From: Nicola Moore
Sent: 16 March 2022 09:30
To: Keri Matthews
Cc: Clare Matthews
Subject: FW: WA/13/22/NMA - required drawings and plans

From: Nicola Moore
Sent: 03 March 2022 10:31
To: Keri Matthews [REDACTED]
Subject: RE: WA/13/22/NMA - required drawings and plans

# PROPOSED FLOOR PLAN - FIRST FLOOR

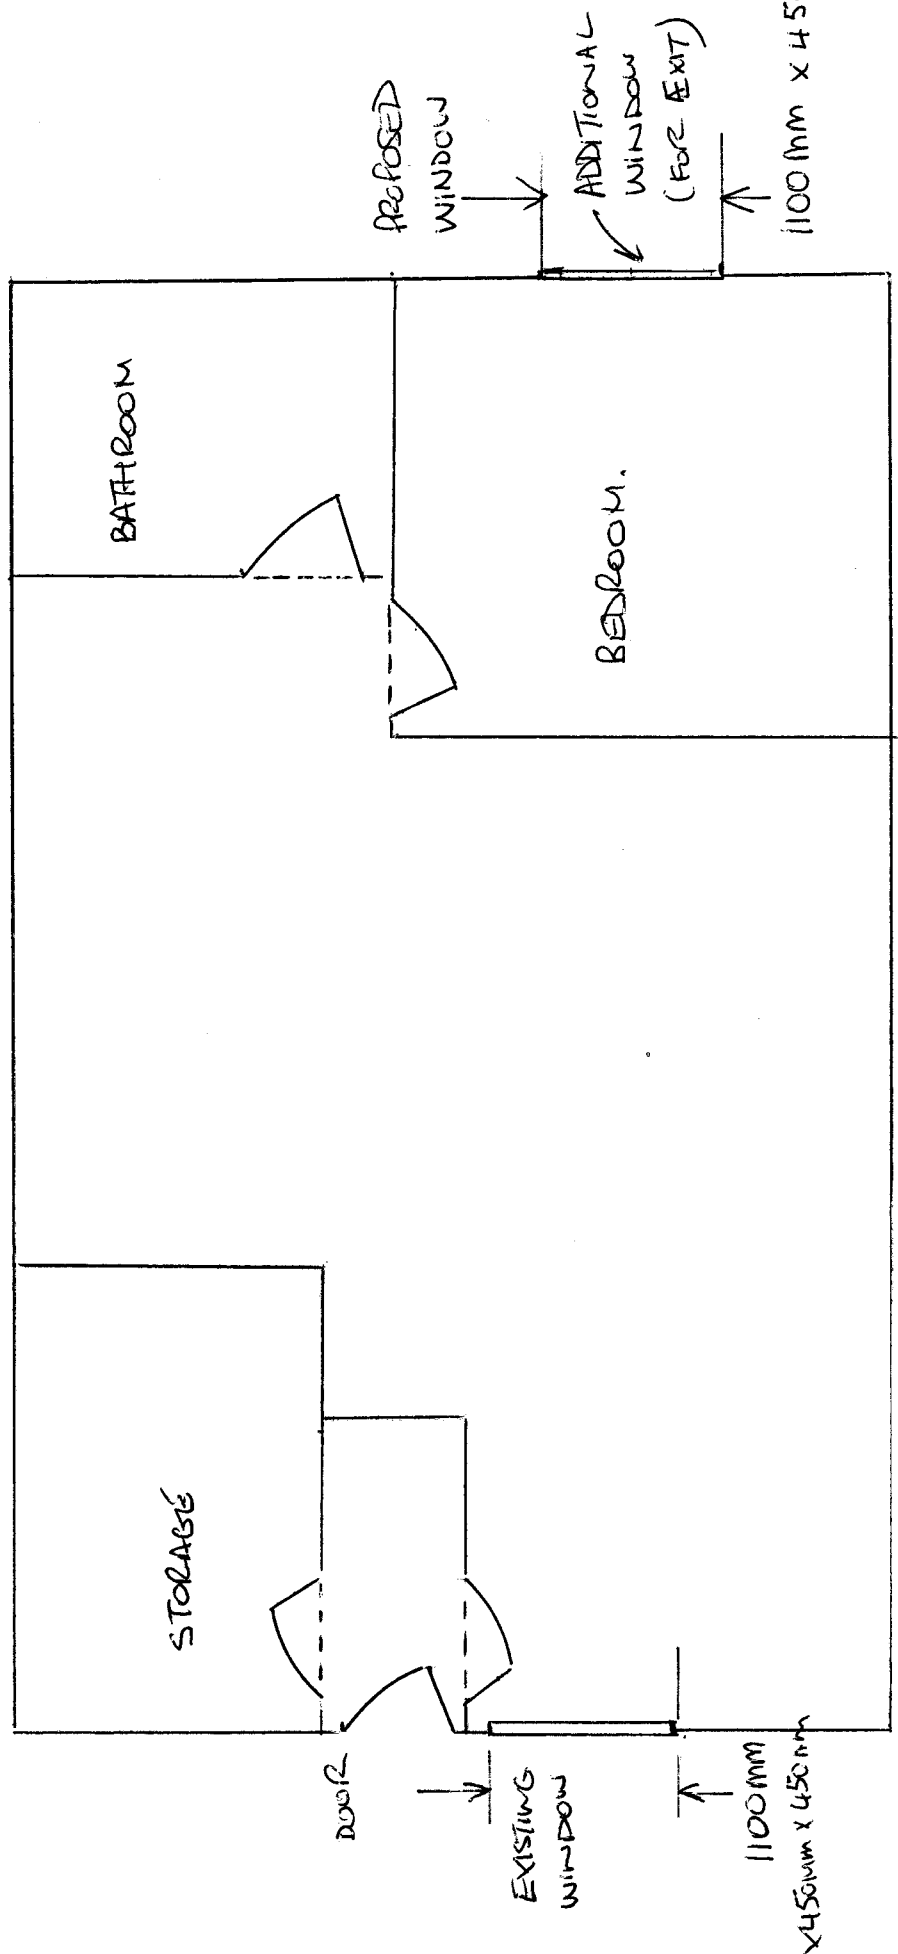
- Proposed Floor plan – is this for the Ground or First Floor? Please label accordingly and re submit. As the amendments are on both floors, we will require both floor plans.
- The plans do not scale correctly, the windows on the first floor both measure 1.30m. Please remove all references to the scale (1:50 and 1:100), and provide clear dimensions for the proposed doors (the window dimensions on the application are: 450mm x 450mm at 1100mm from the floor on east aspect of first floor), for clarity please confirm this is correct. When providing the dimensions please ensure it is clear which window/door they relate to.
